**Our Case Number:** ACP-323950-25

**Re:** Flood Relief Works at Graiguenamanagh, Co. Kilkenny & Tinnahinch, Co. Carlow  
Graiguenamanagh, Co. Kilkenny & Tinnahinch, Co. Carlow

## **Graiguenamanagh/Tinnahinch Flood Relief Scheme**

**Case Reference: 323950**

DRAWING TITLE
FLOOD RELIEF WORKS
UPSTREAM STORAGE AREA – DUISKE RIVER
ACCESS ROAD PLAN & DETAILS

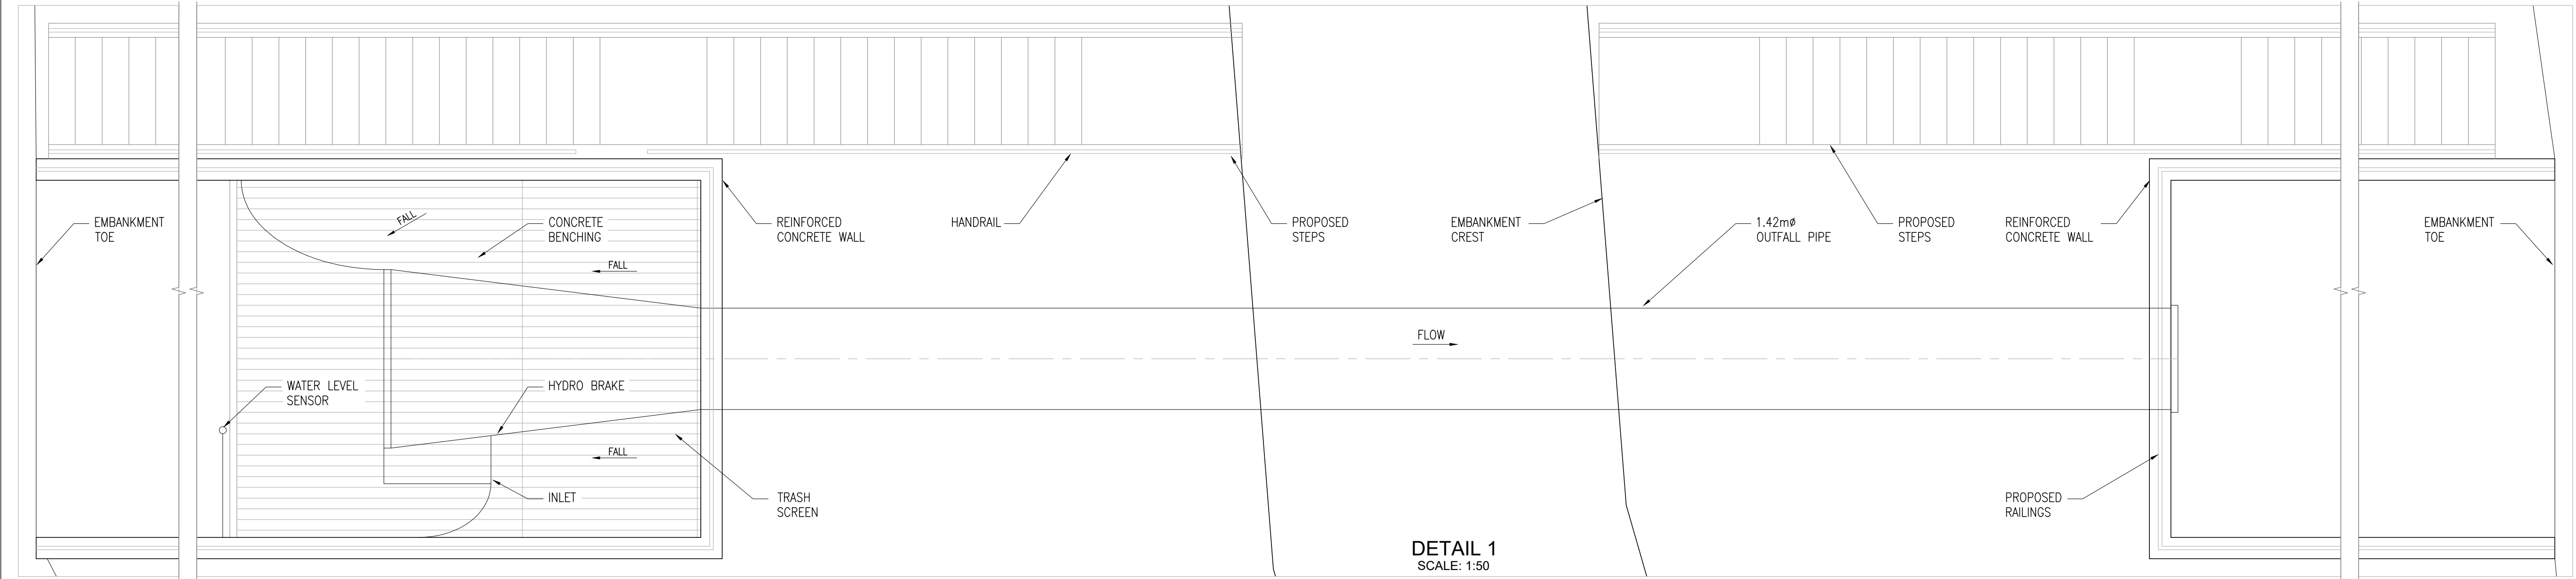
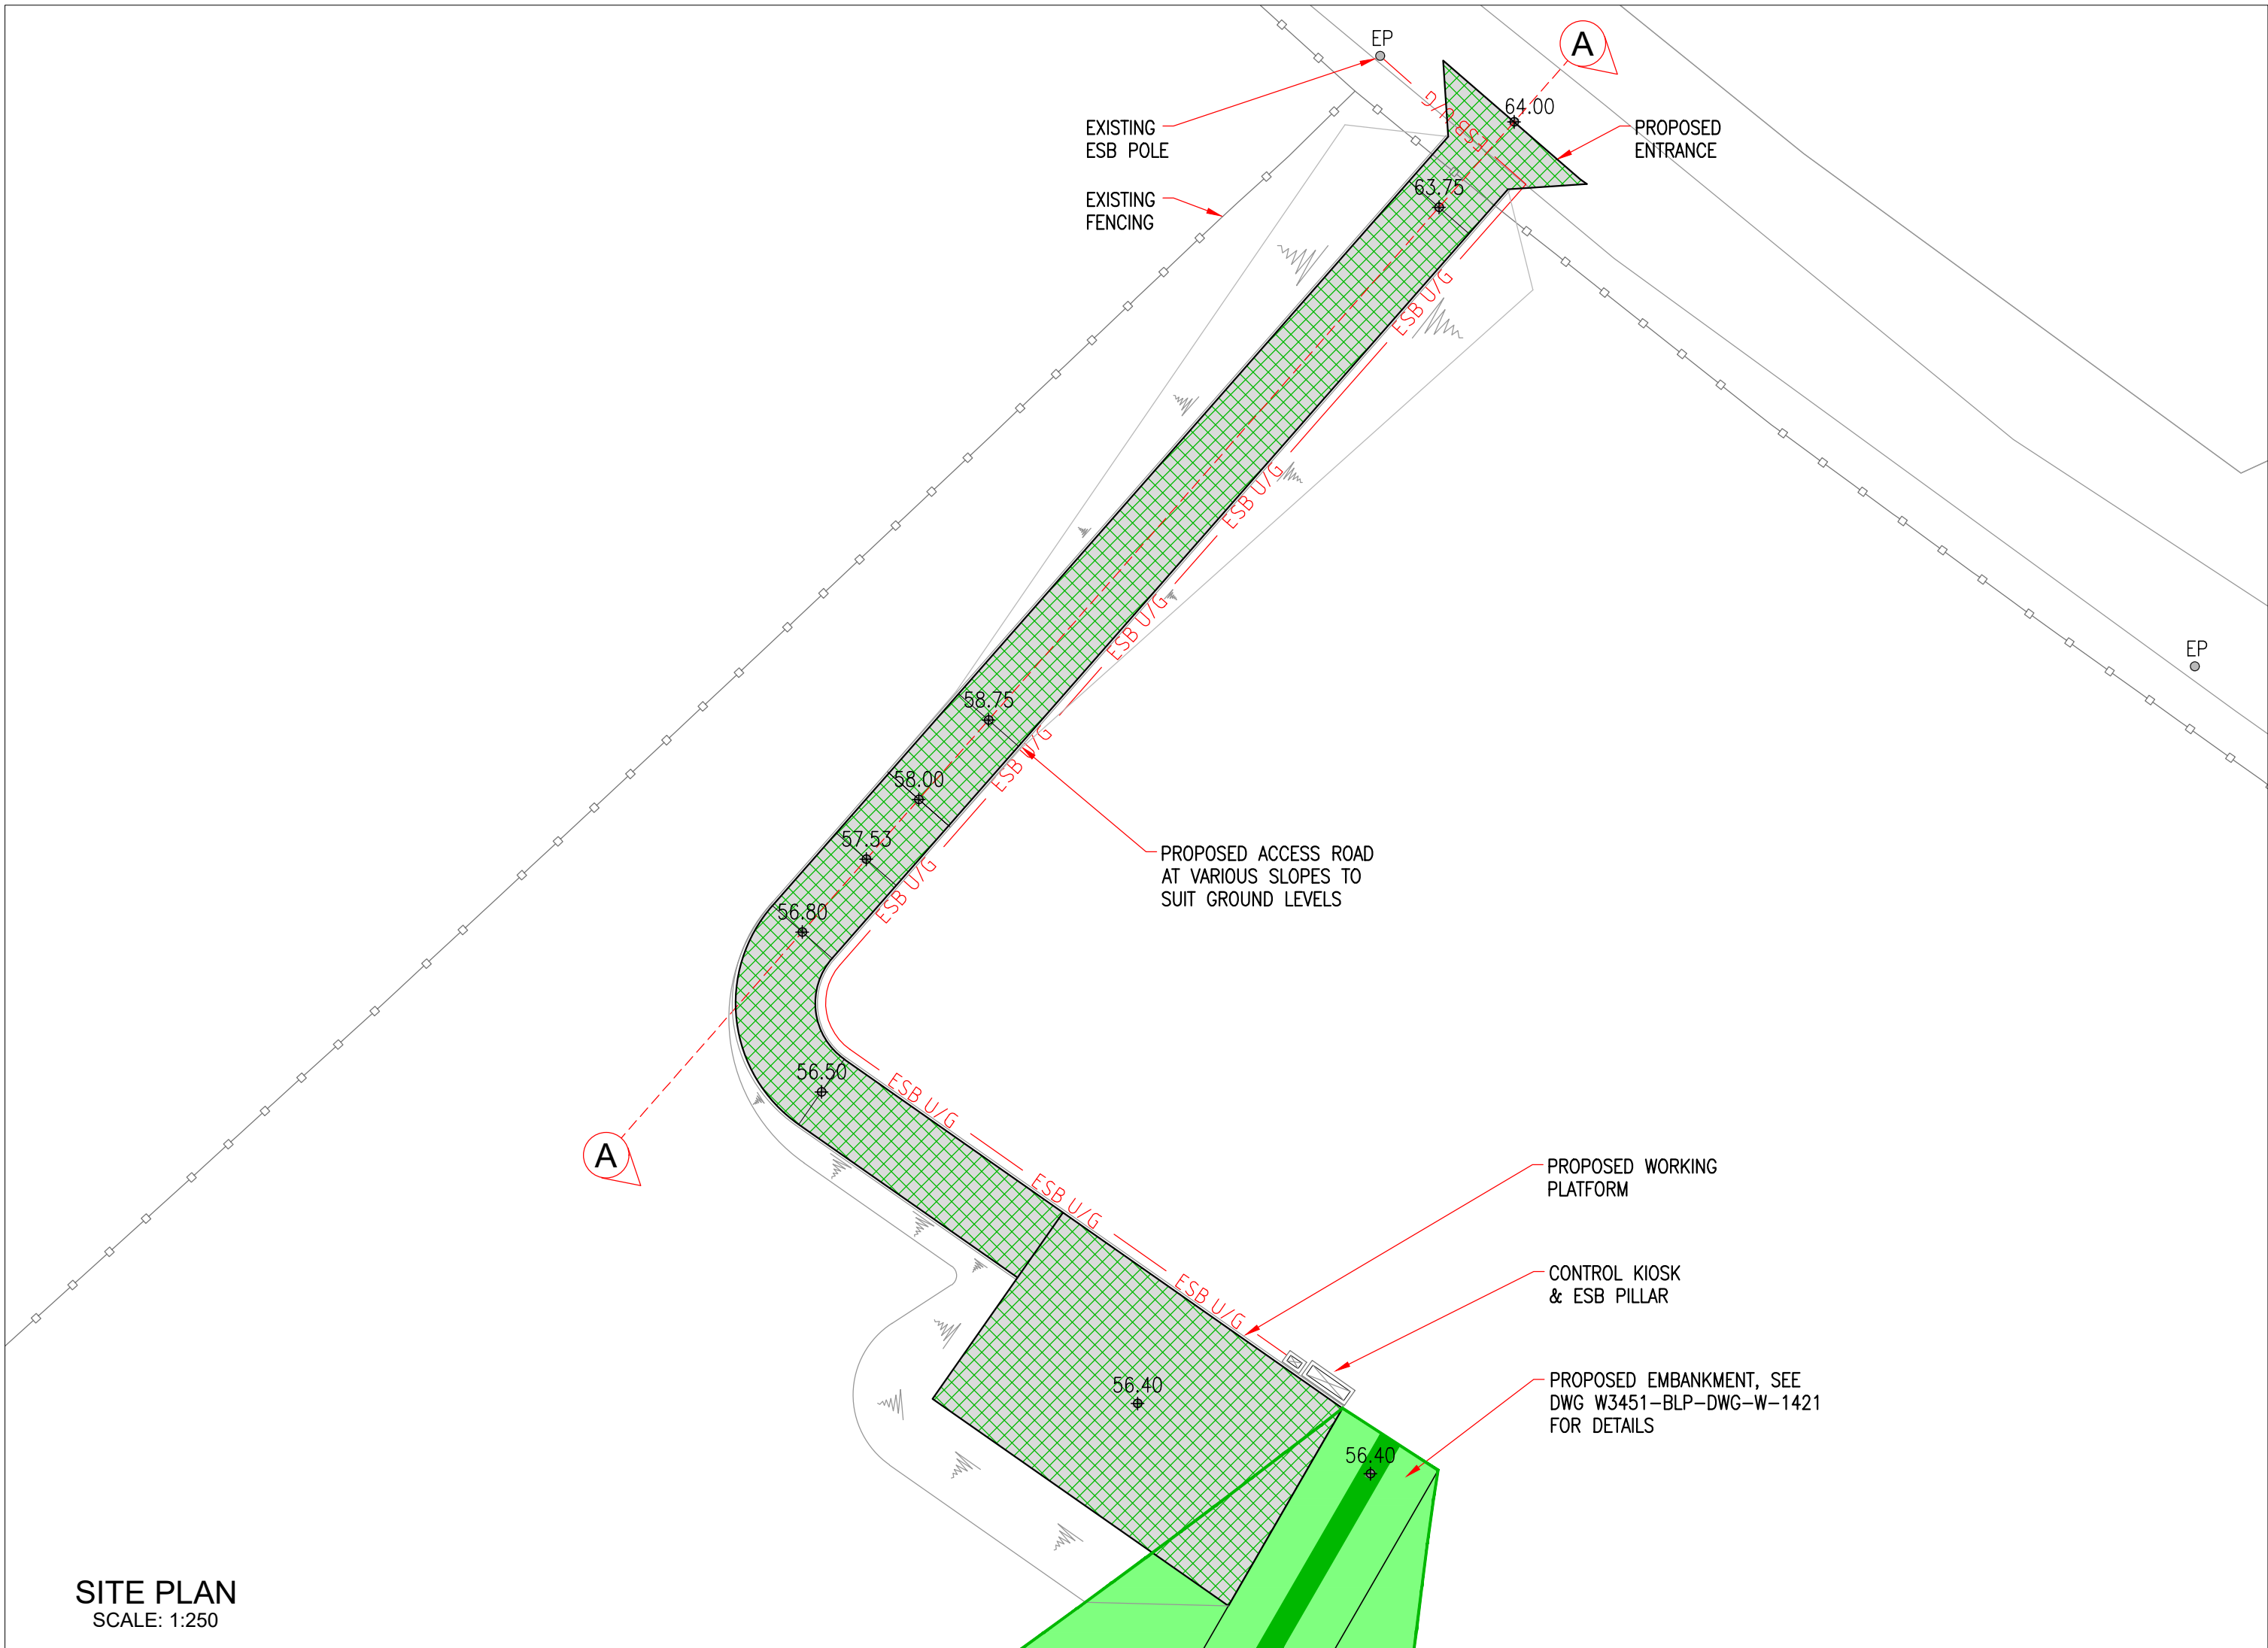
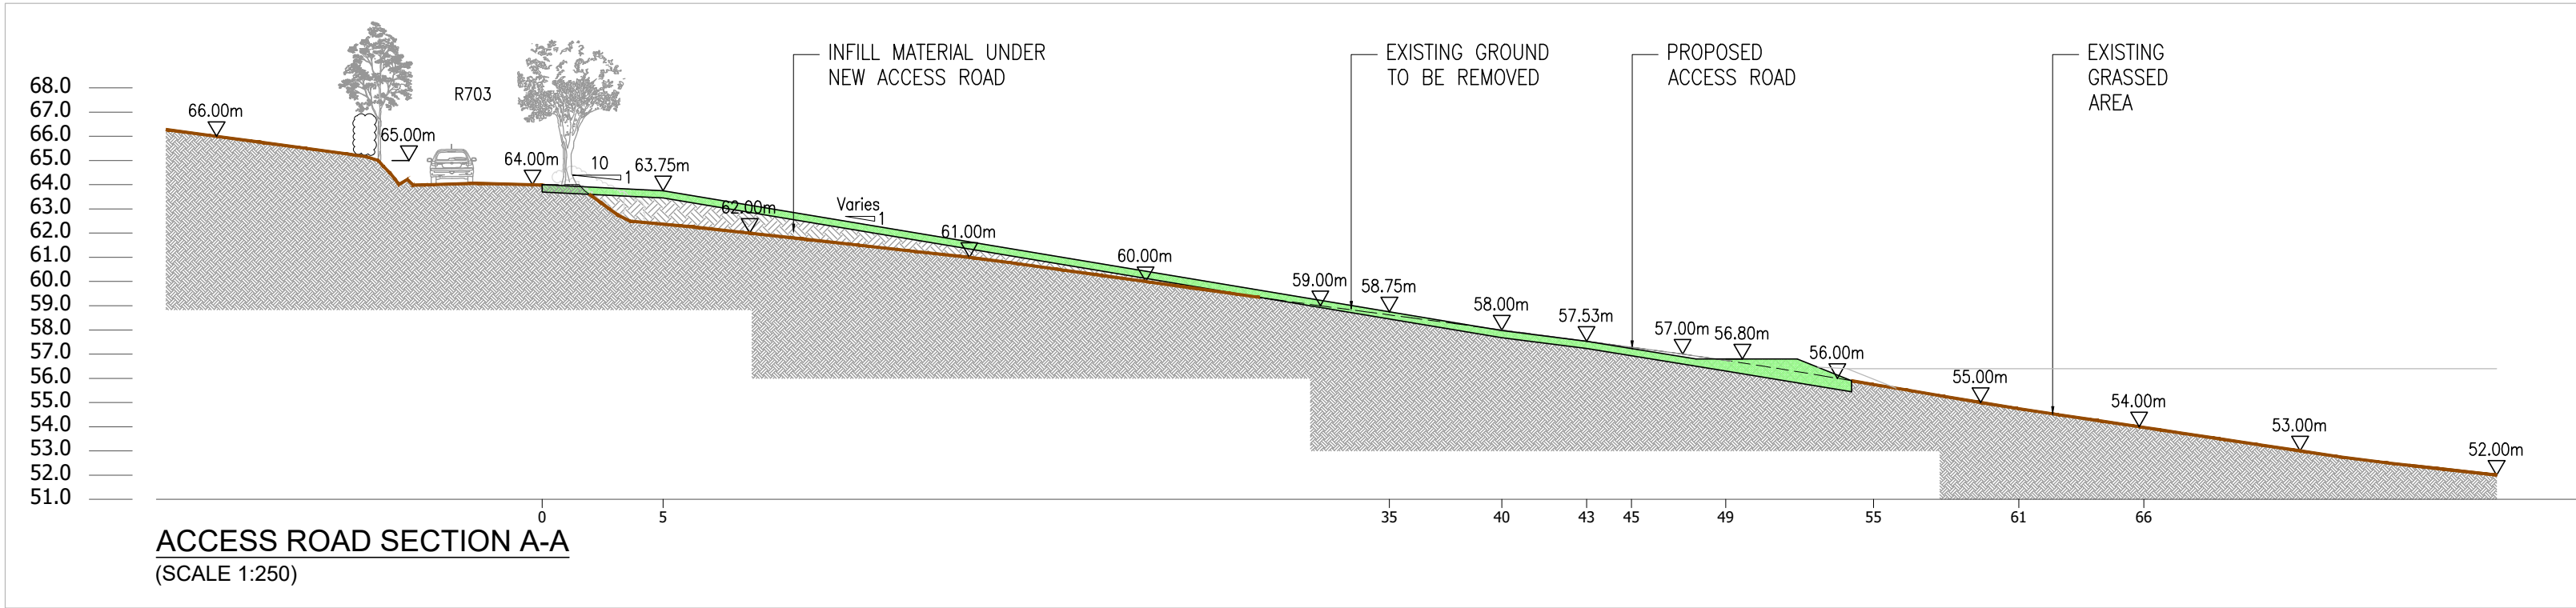
- Regarding the operation of the proposed flood storage dam, IFI note from the documentation provided that there will be a loss of 60m of habitat at the dam itself. The EIAR states that residual effects are considered imperceptible as the alteration is to less than 60m of a 23km river. It is not clear what the 23km length of channel referred to here relates to. The Duiske River is not 23km in length. As described above there are significant impacts to the habitat of the Duiske downstream of here linked to abstractions while the extent of suitable salmon spawning habitat upstream of the dam/weir on UE lands is relatively short. IFI question that the assertion that the residual effects are imperceptible.

- As detailed above, the Duiske River in the vicinity of the proposed flood storage structure represents some of the best salmon spawning habitat on the Duiske. In the event of significant salmon spawning on the section of channel upstream of the proposed flood storage dam sections of channel with salmon redds will be temporarily in waters that are several metres deep. Several metres deeper than would ever have occurred here naturally, historically.

- IFI request clarification on the length of time/duration that this unnatural level of impoundment occurs.
- It is important that the applicant can demonstrate that the operational phase of the flood storage dam will not negatively impact upon salmonid recruitment in the section of channel where flood waters are stored.

- IFI request clarification on what/if any bed stabilization measures are proposed immediately downstream of the flood storage dam. It is important that the applicant fully quantifies alteration to habitat in the section of channel downstream of this structure.

- Related to the above point we ask that the applicant detail what measures are proposed to ensure that scour/erosion does not occur in the section of channel immediately downstream of the flood storage dam. Of concern to IFI is that if scour does occur there is potential for a barrier to fish passage to develop over time.
